# Former Nestlé Factory

London Borough of Hillingdon Access Officer Responses

October 2017

CYCLES PARKING LAYOUT - GROUND FLOOR PLAN

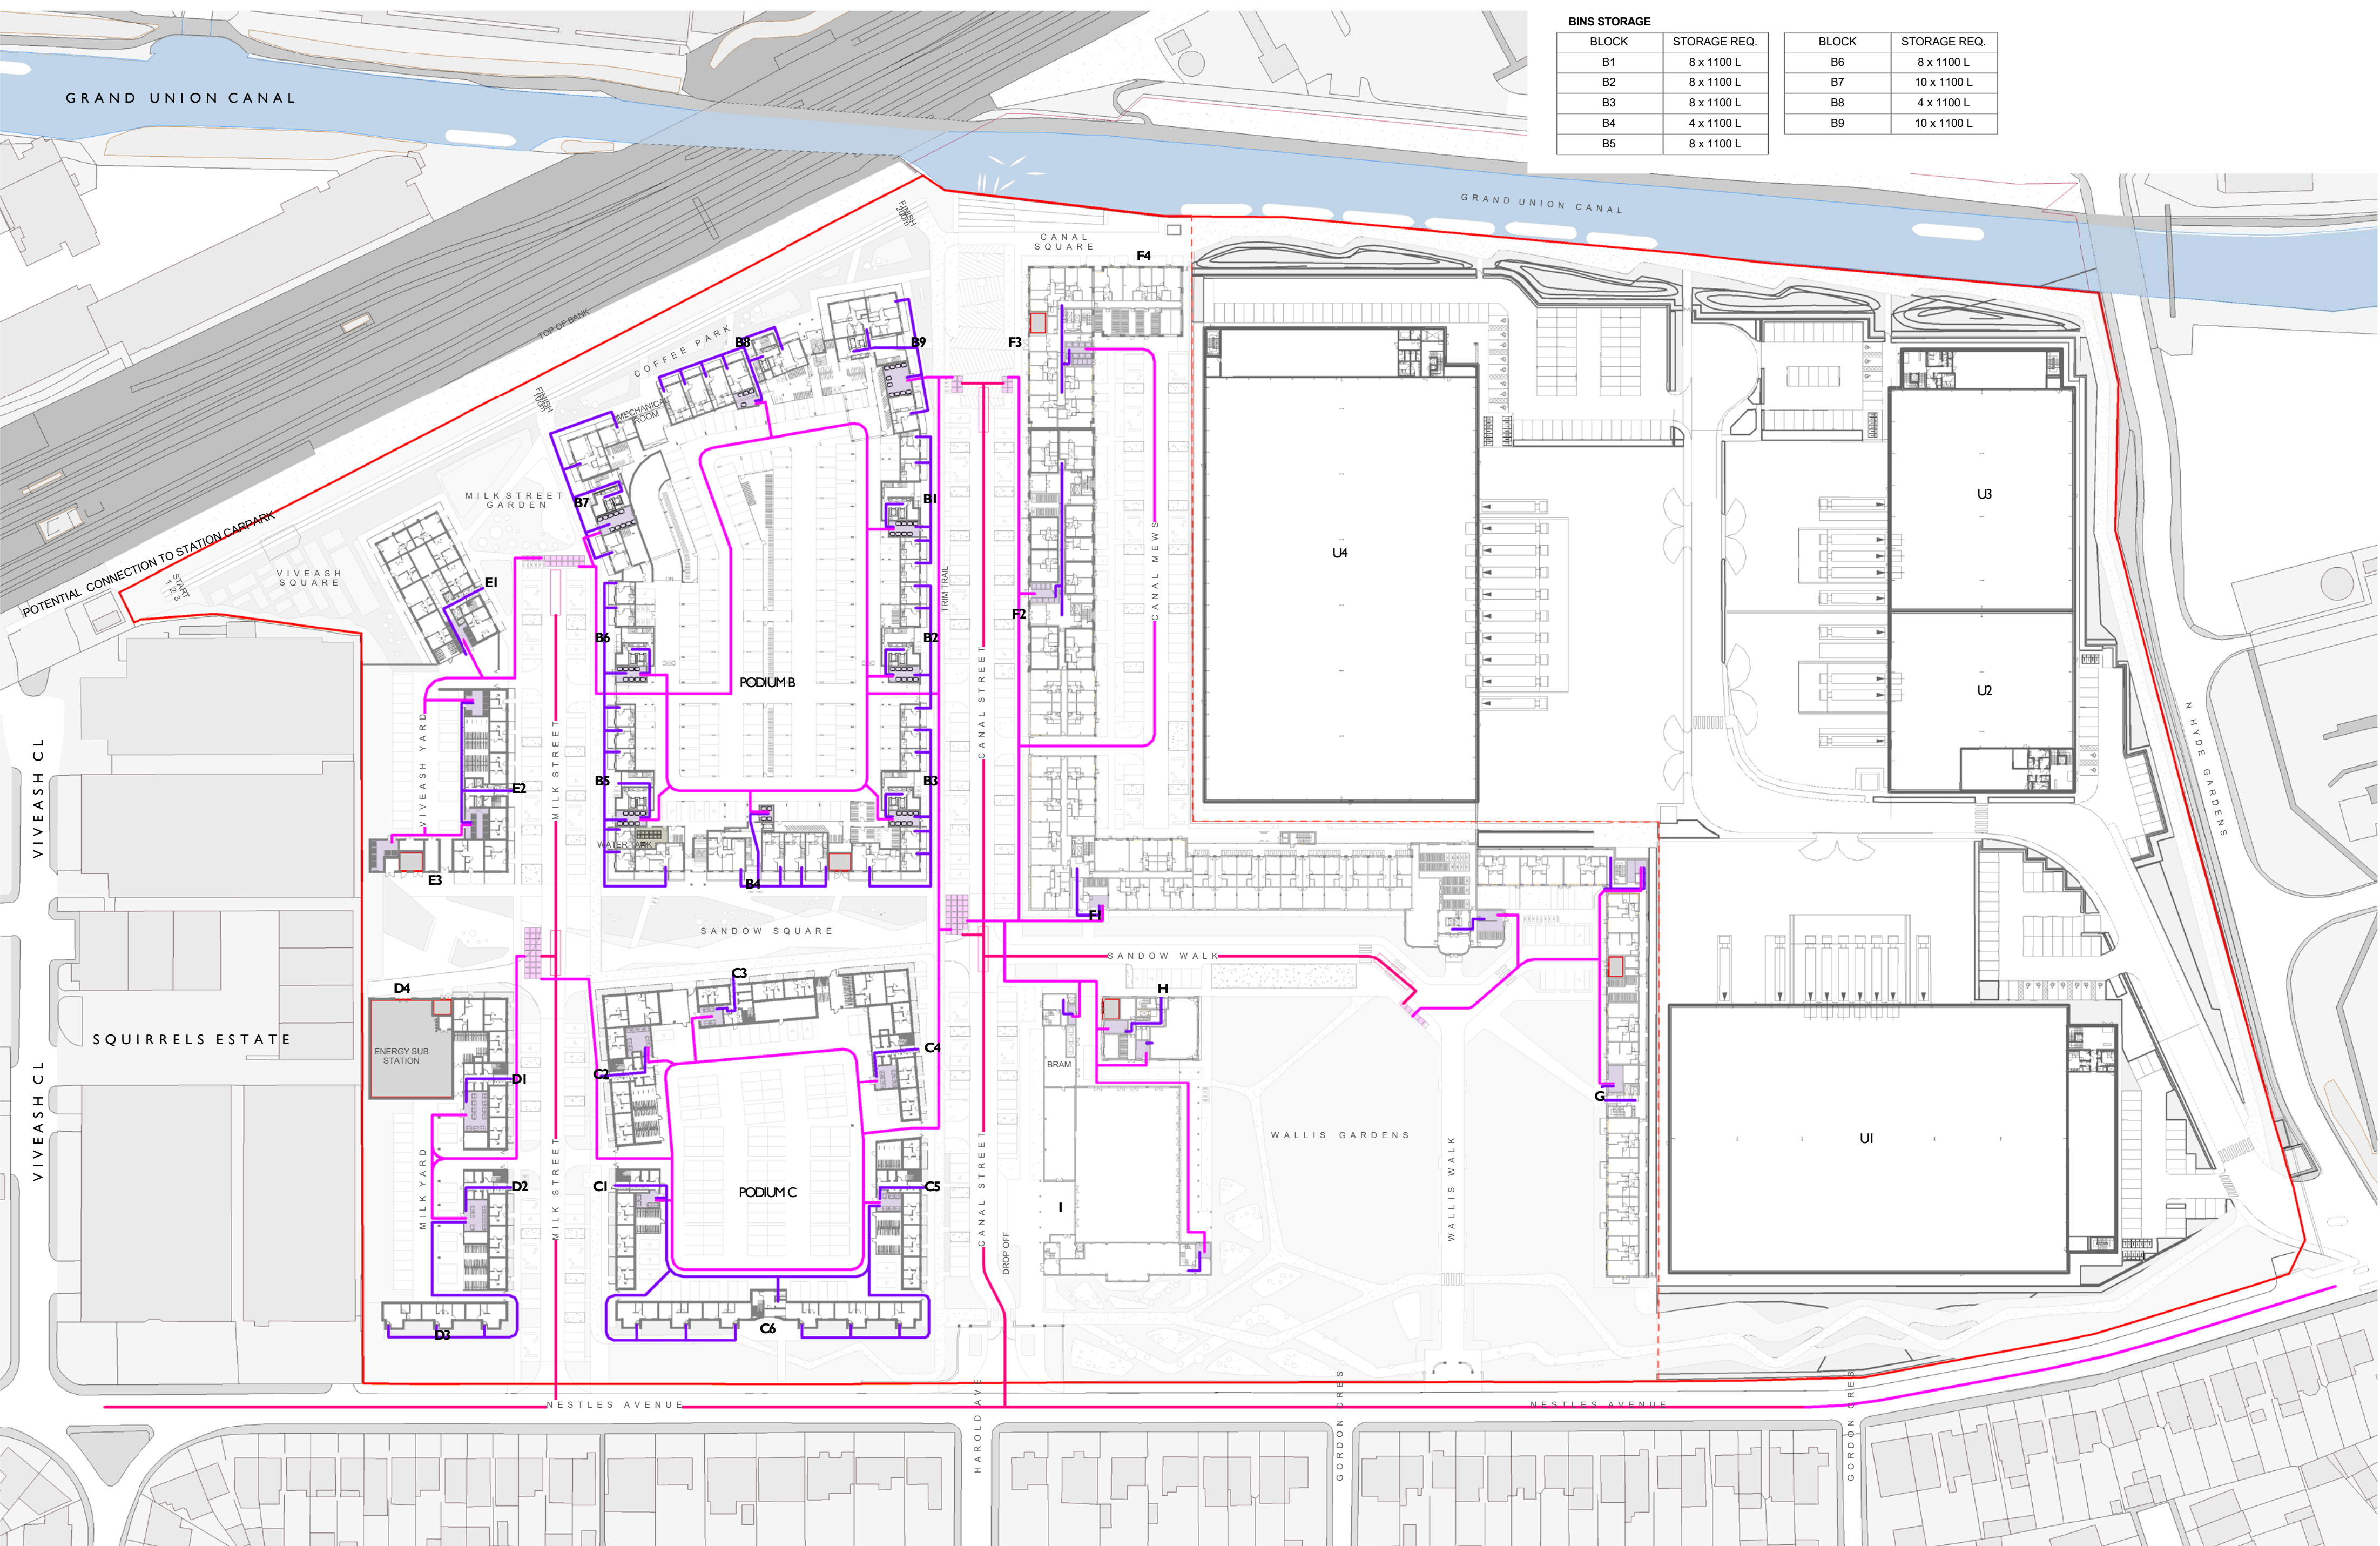
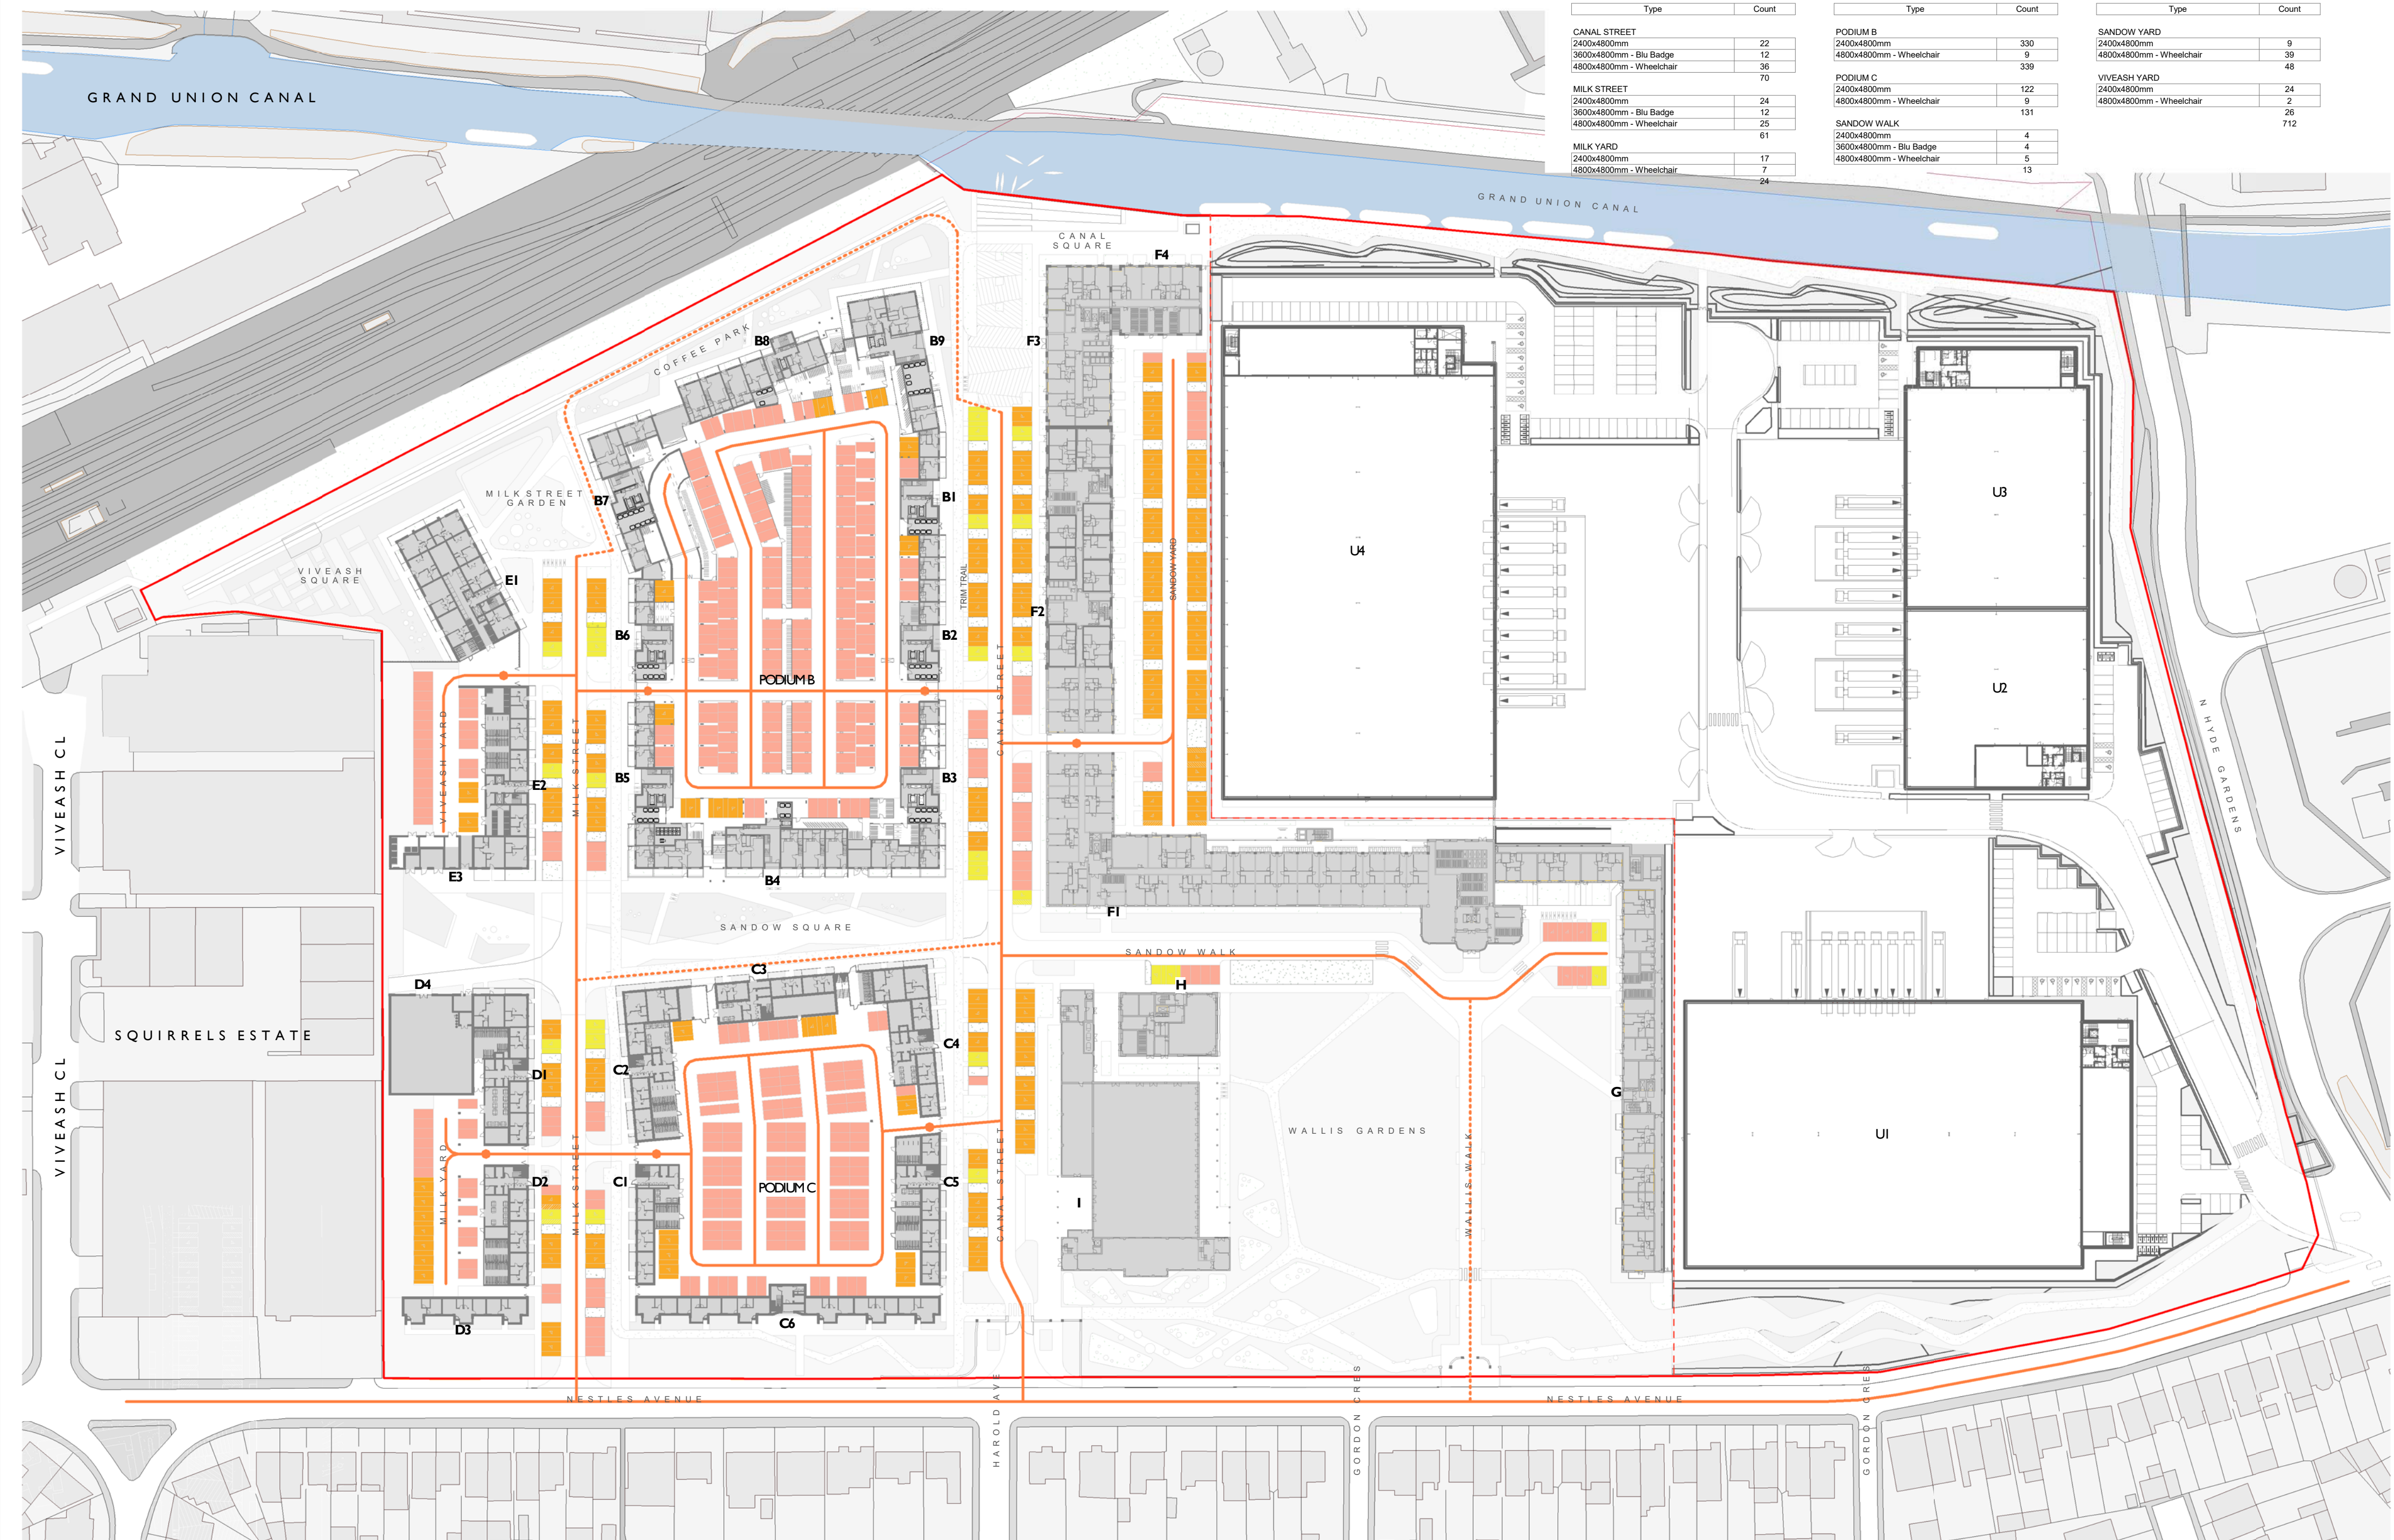
Number	Access Office comments	DBA Comments / Recommendations	Status
2	<p><b>The design of accessible parking spaces, for residents, employees and visitors, should cater for high sided vehicles with side and rear wheelchair access.</b></p>	<p>Accessible bays have been designed to comply with AD M requirements: residential accessible bays provide a 1200mm clear access zone to both sides as per AD M Volume 1; Blue Badge bays for public use provide a 1200mm clear access zone to one side and the rear as per AD M Volume 2.</p> <p>Surface parking for residential and commercial uses will be distributed throughout the development, including accessible parking bays in close proximity to all the entrances.</p> <p>Additional accessible bays for residents will be provided at GF and basement levels under the podiums in blocks B and C. Accessible bays within the covered parking will have a clearance of 2800mm above the bay and 2650mm above the circulation routes, in line with BS 8300 recommendations, to allow for high-sided vehicles.</p>
